PLANNING AMENDMENT

H11/0252/97

STORAGE BUILDING.

Description: Proposed storage building

BLOCK & LOCATION PLAN

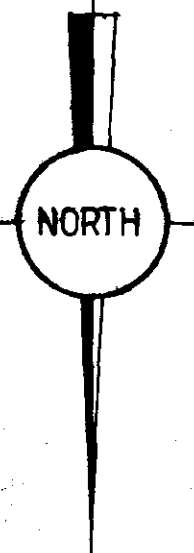
2.5m FENCE ADDED
EARTH BOND INCREASE TO
3.0m HIGH

Amendment: 2.5m fence added. Earth bund increased to 3.0m high
(Drawing No. 9644:2)
